Planning Application No: 3/2025/0002

Location: Land rear of Sabden Village Hall, Wesley Street, Sabden, BB7 9EH.

With regard to the above, we have great concerns of the impact on us, the day-to-day implications it would give if approved, along with a number of inaccuracies in the submission, particularly the fact that [REDACTED] the proposed car park.

Title:
TREE IMPACT PLAN
in Relation to Proposed New Car Park

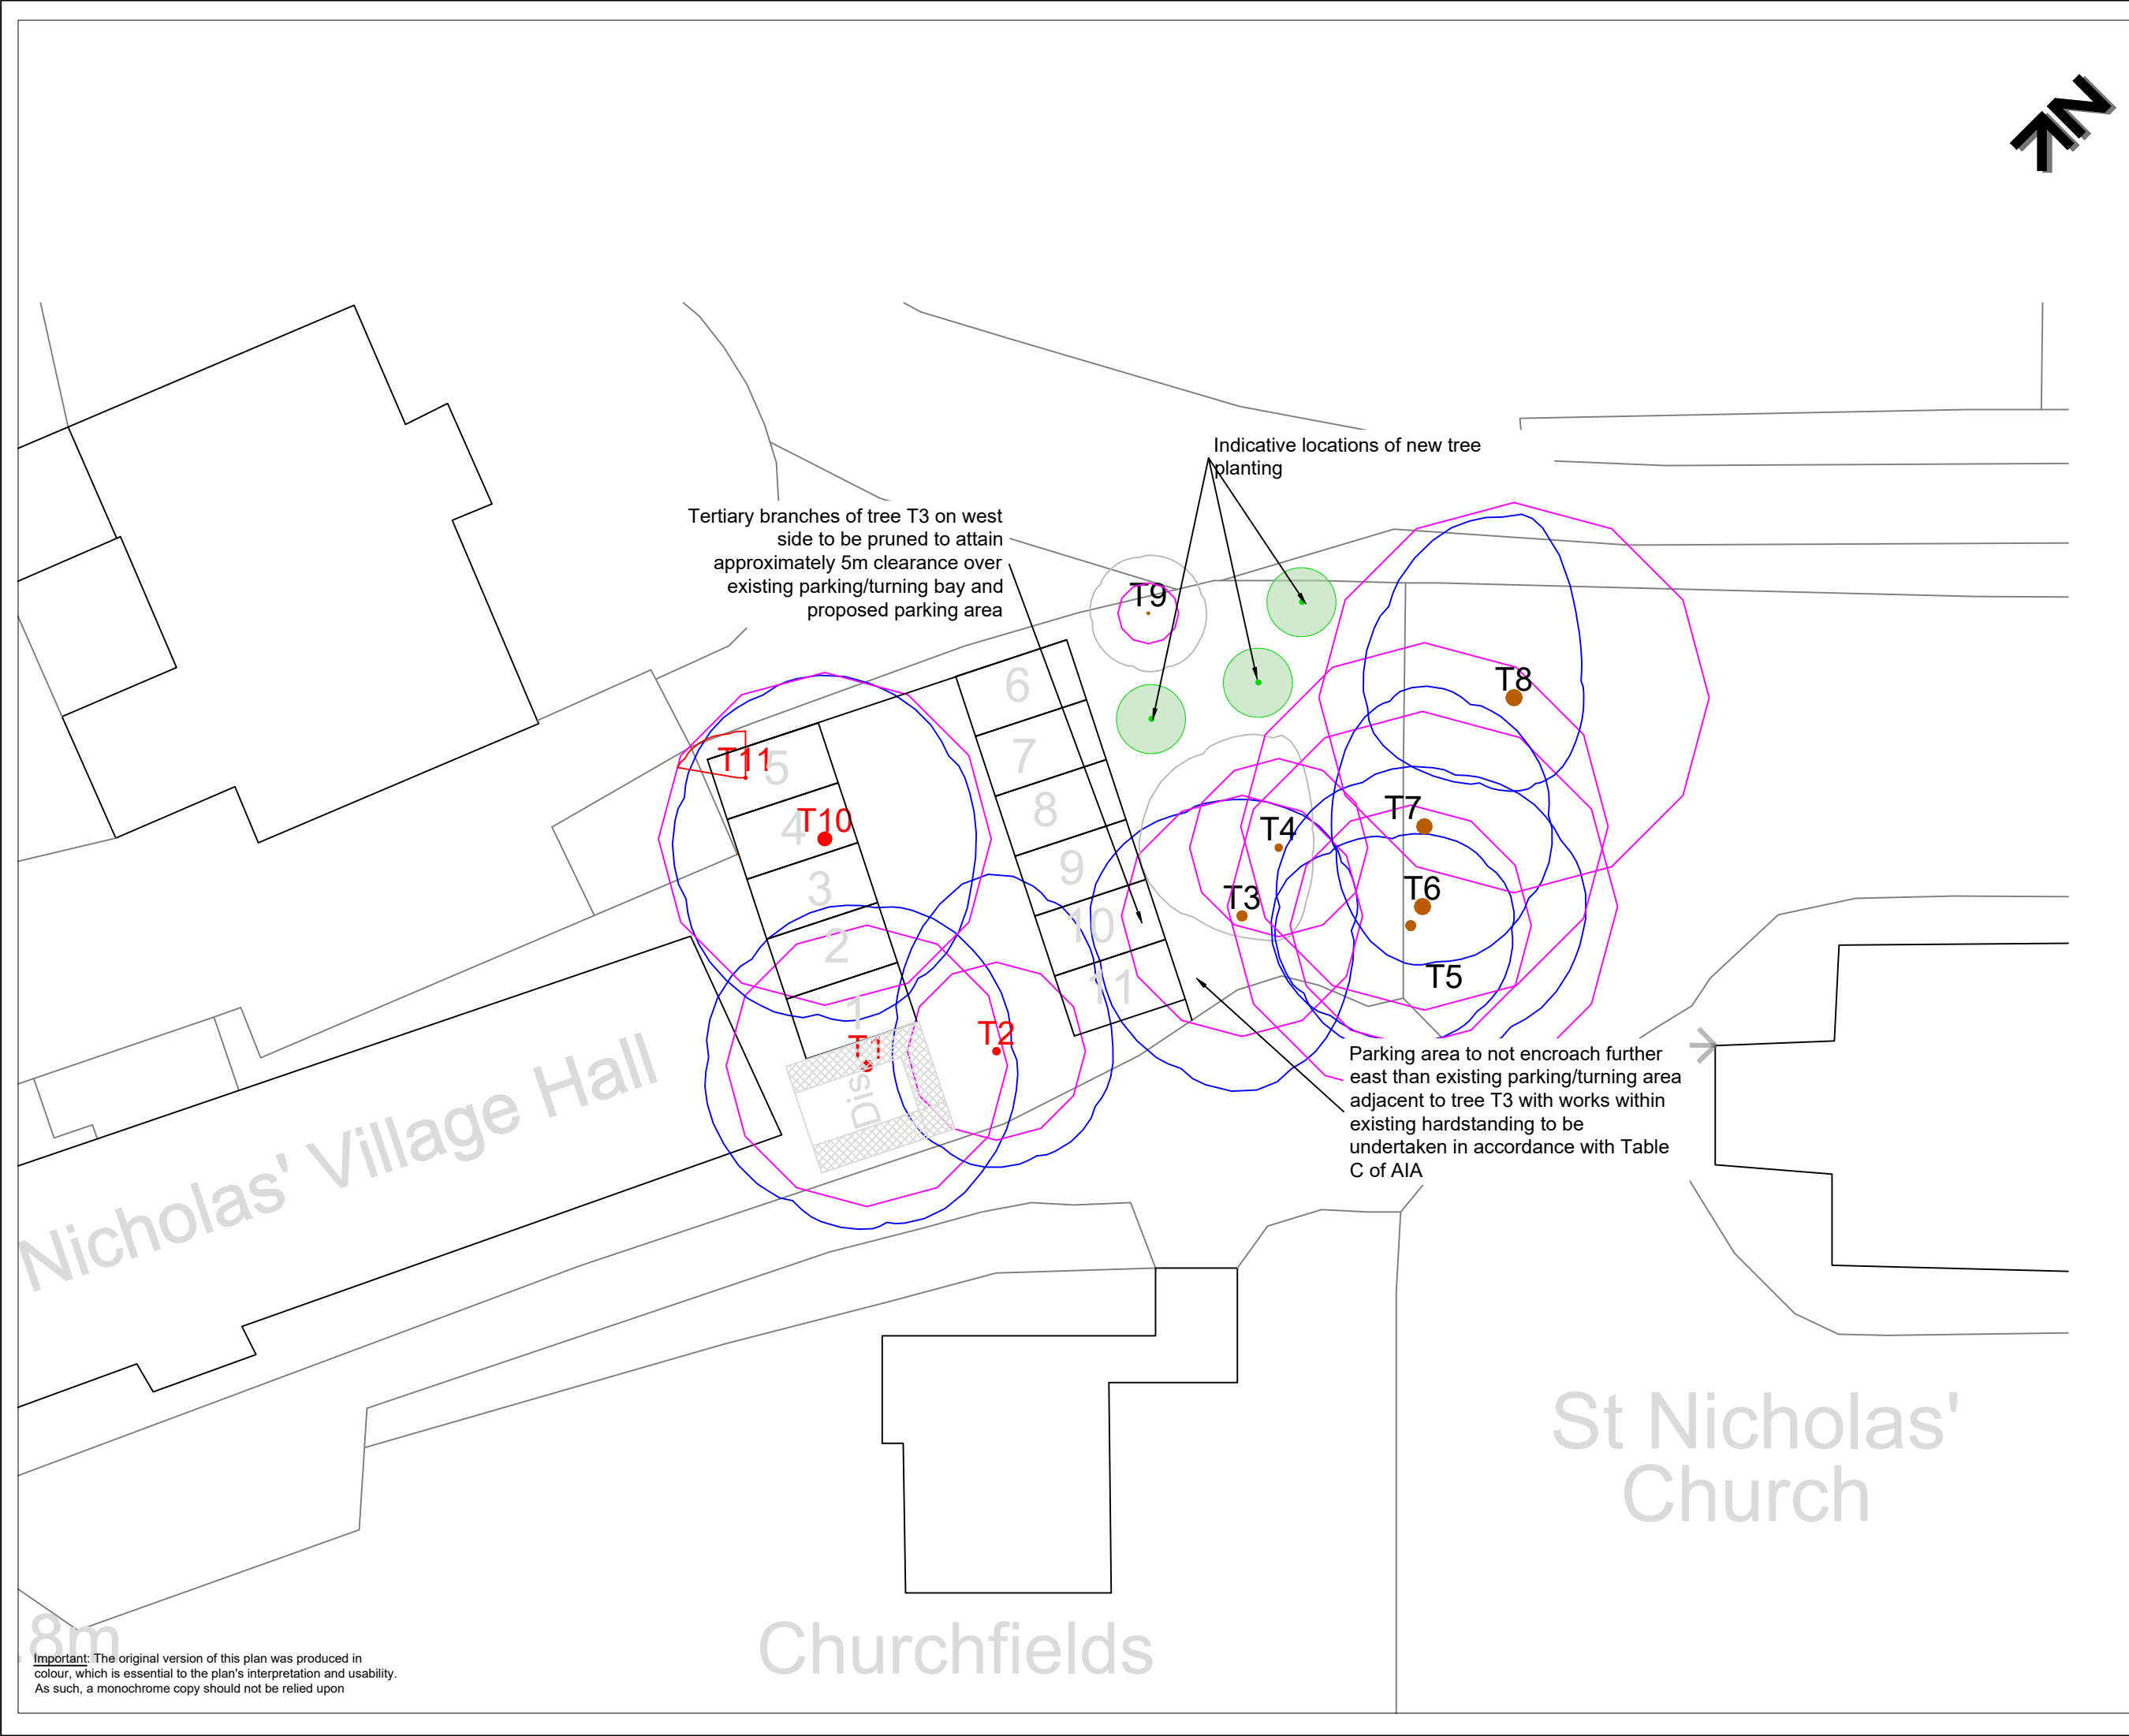
This states that the flowering cherry is 5 metres and that the beech tree is 9 metres, these have been materially understated. The flowering cherry is at least 10 metres, and the beech tree is at least 12 metres tall.

Tree 1 – Cherry - Its removal poses minimal arboricultural impact due to its moderate ecological and amenity value.

This is a specimen cherry tree due to the combination of the two distinct plant parts that have been joined together (scion and rootstock) to create pink blossoms on one side and white on the other. Contrary to having 'moderate amenity value' it is actually the only flowering tree on the grass area, it was obviously deliberately planted centrally, and as such, is very impactful. Its loss would be notable.

Tree 2 – Beech – described twice as semi-mature and once as mature! T4, the tree behind T2, is described as a mature oak tree and yet the beech tree is far more substantial as anyone looking at it can see.

We would suggest that the applicants re-visit their arboricultural report to ensure it reflects the correct facts.
